Memorandum

To:	Norine Allerdice	Date:	October 27, 2022
From:	April Ng		
Project:	Butenwieser/Wiley Residence 6838 96 th Ave SE Mercer Island, WA 98040 King County APN 302405-9010	File No:	2205-199
Subject:	Building Permit Review 1 Response

The comments are restated below, followed by responses. Updated drawings have been clouded with Revision 1: 10/27/22 Building Permit Resubmittal.

GARAGE AND SHED PLANS
S151

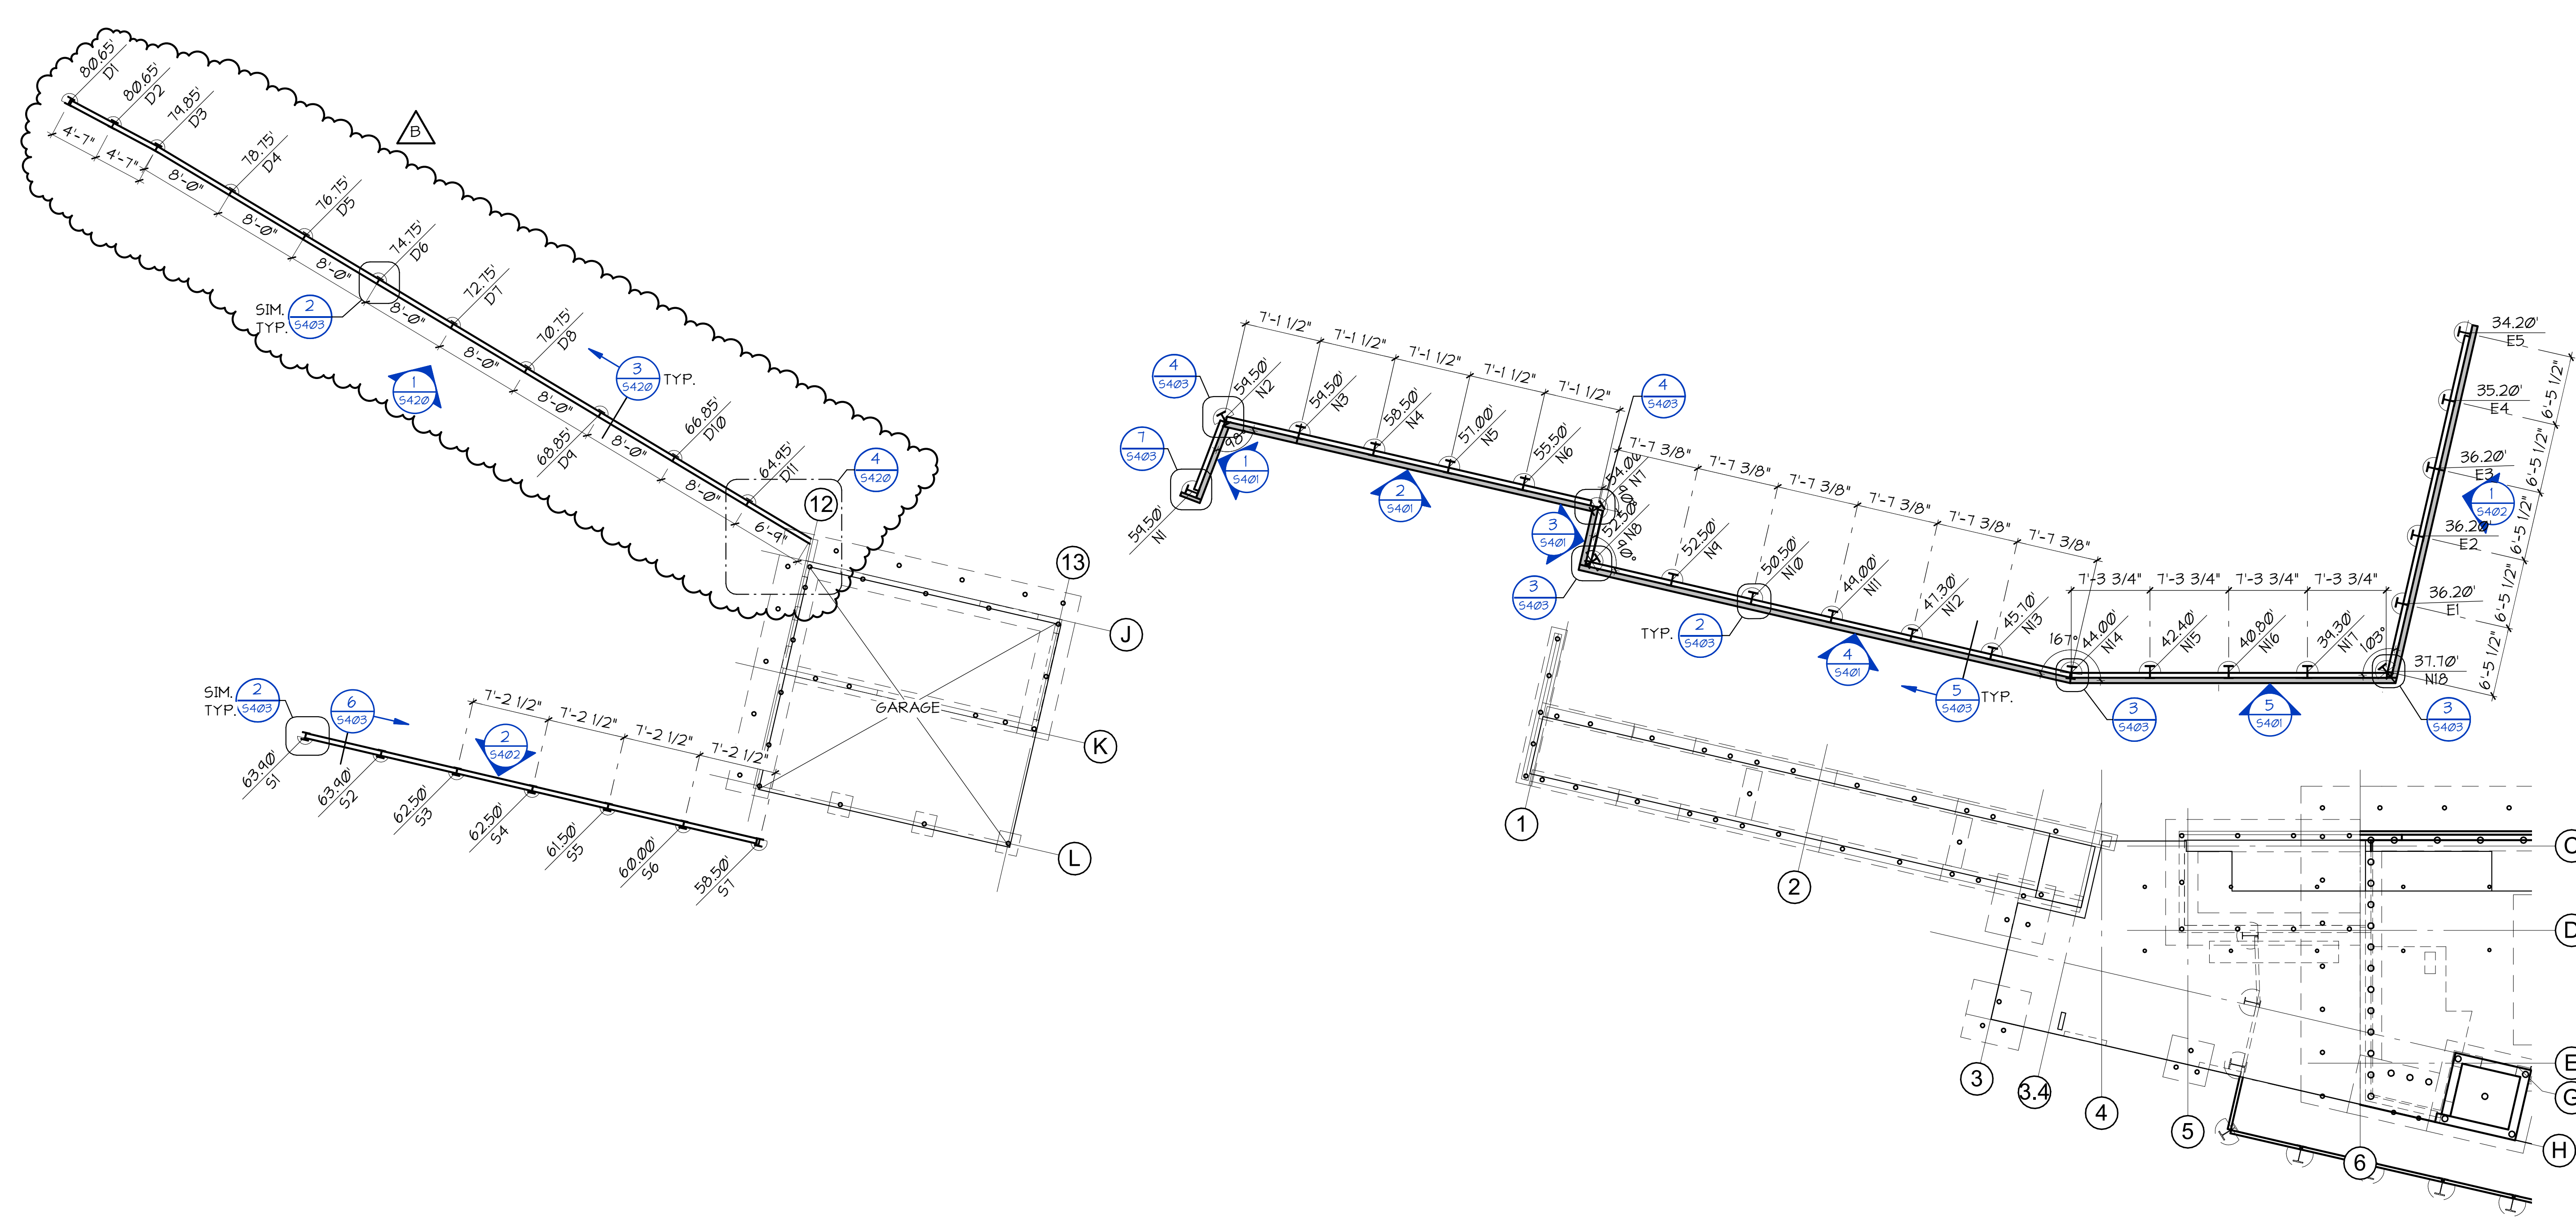
Tree Review		
<i>Comment</i>	<i>Response</i>	<i>Document Ref.</i>
C200B	A shed that is above grade on piers is proposed to replace the existing shed. Grading in this area is proposed to be	C101A, C101B

WETLAND BUFFER IMPACTS ASSESSMENT

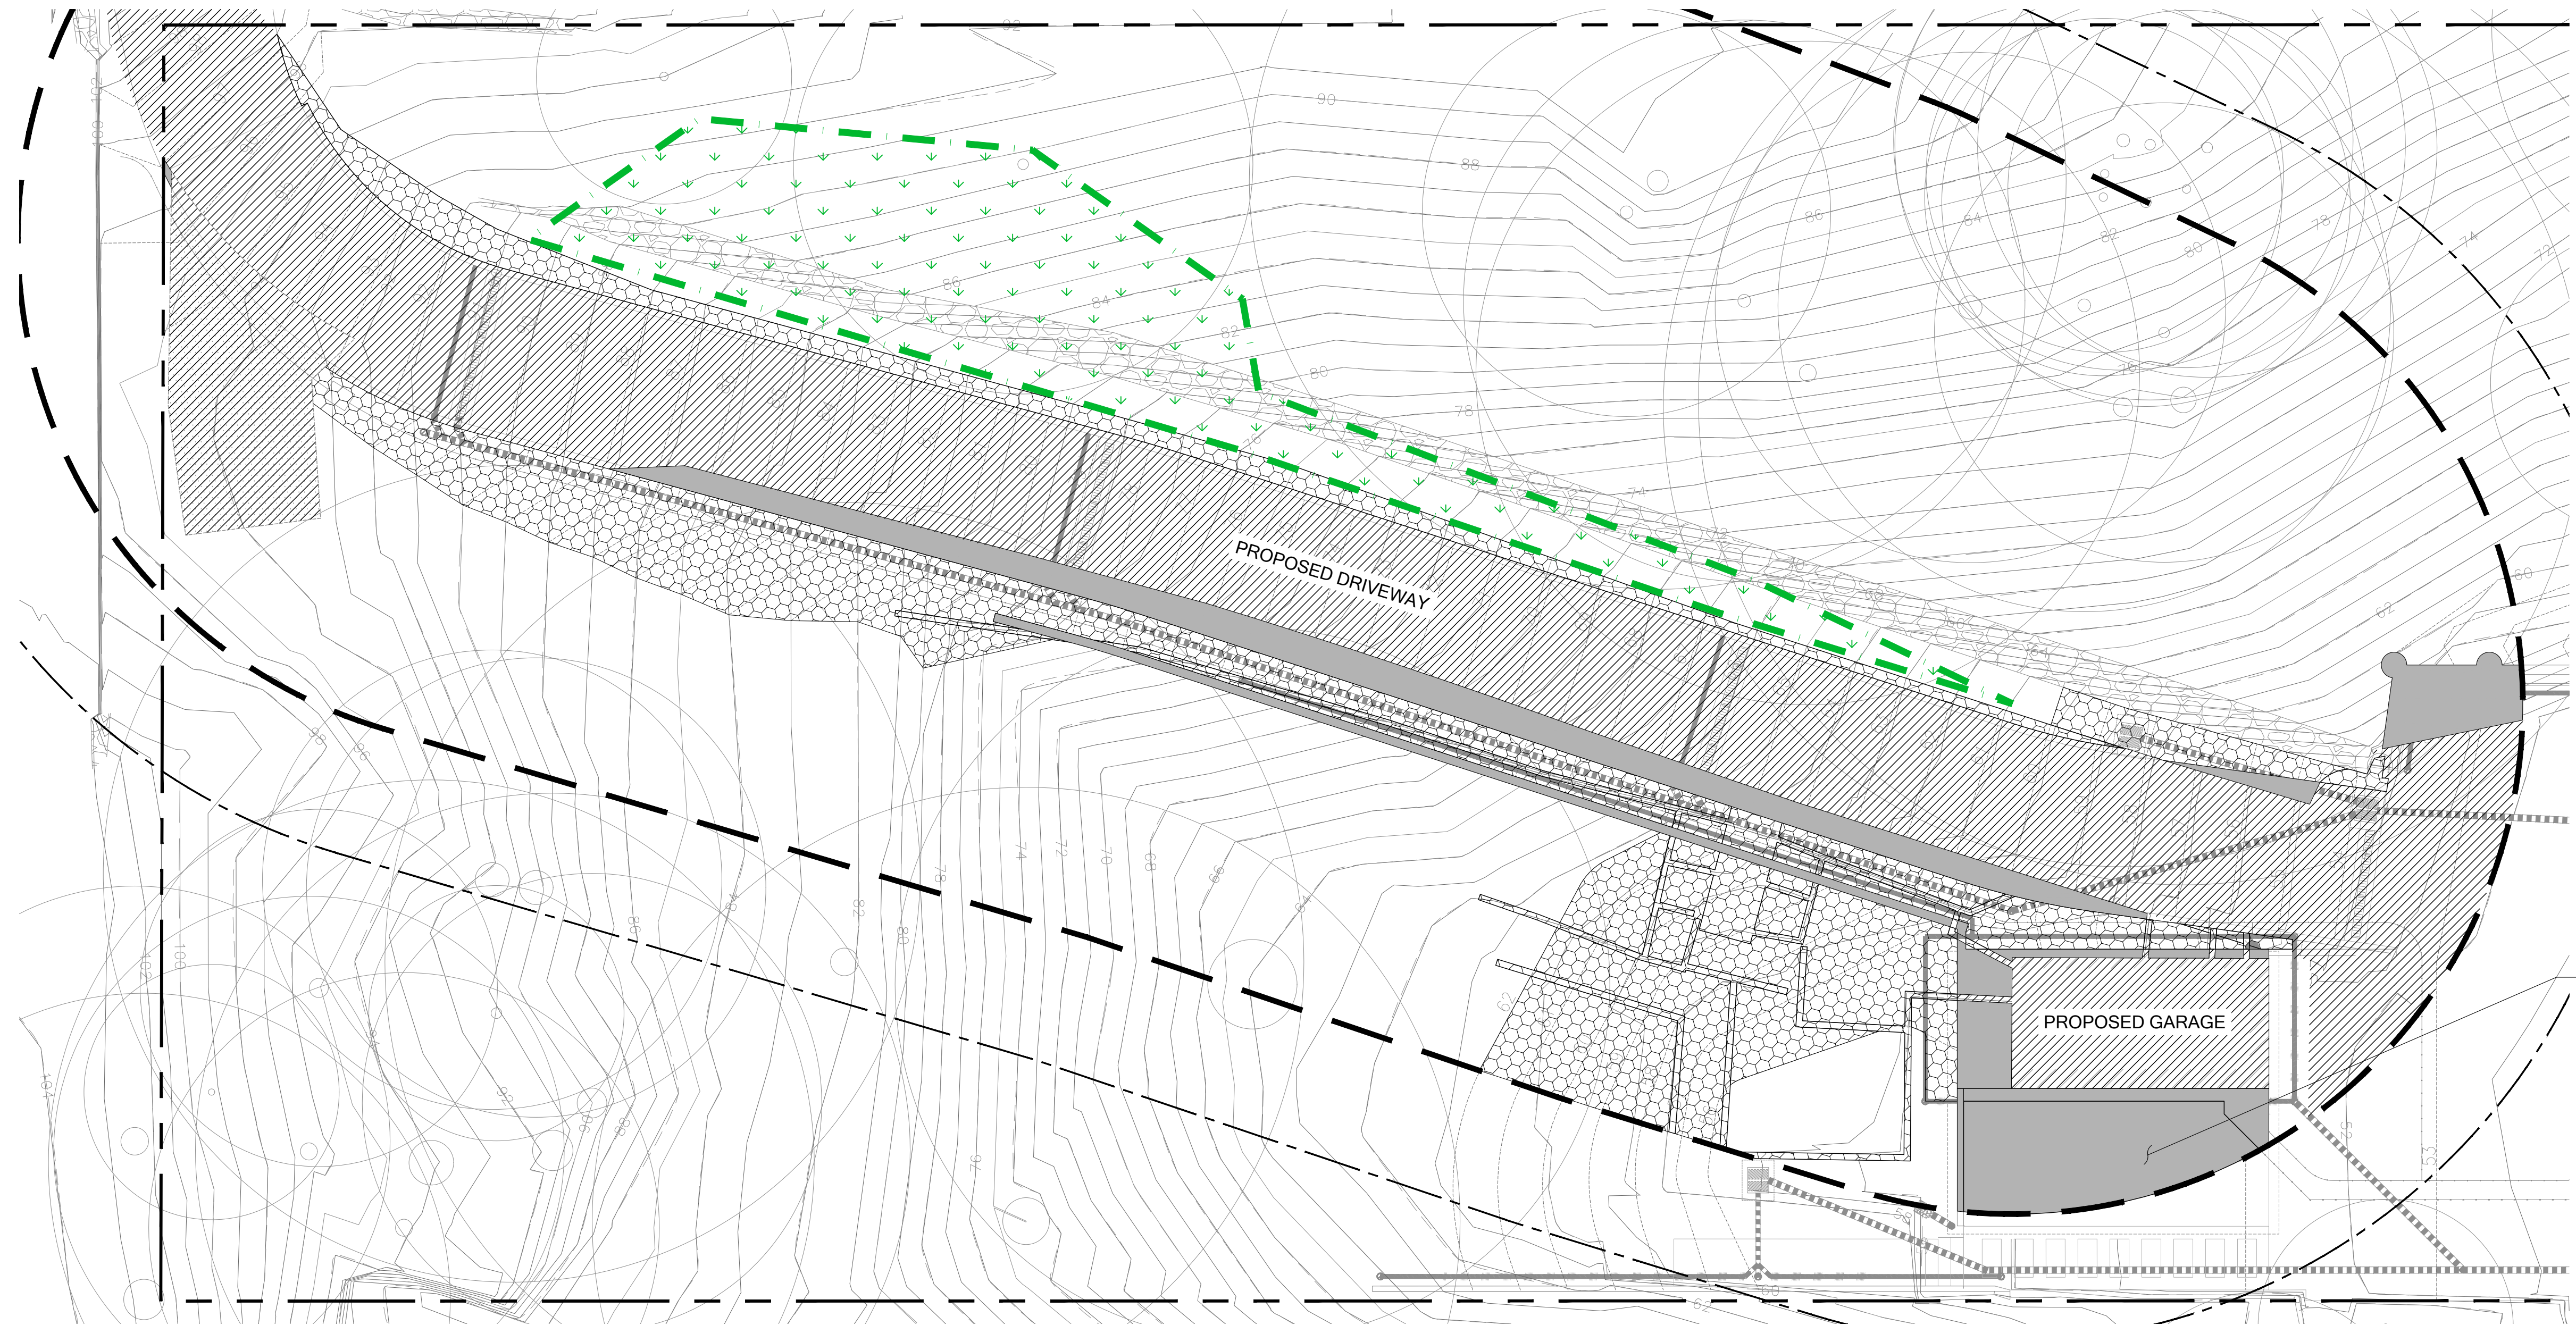
G200 Include maximum allowed lot coverage and hardscape numbers	Maximum allowed lot coverage and hardscape numbers are included with the calculations on G200 as well as in the Zoning Code Analysis on G100.	G100, G200
G200 Provide a similar code diagram for compliance with MICC 19.13.050(K)(4)(i) for native vegetation coverage over 75% of the 20 ft vegetation area shown in Figure C. Be sure to provide square footage of the area 0-20' from OHWM.	The Watershed Company prepared this plan for Permit Numbers CAO21-007, SHL21-042, SEP21-027 on sheet W5. This sheet has been included as part of the building permit resubmittal. L601 provides additional planting information in this area.	W5, L601
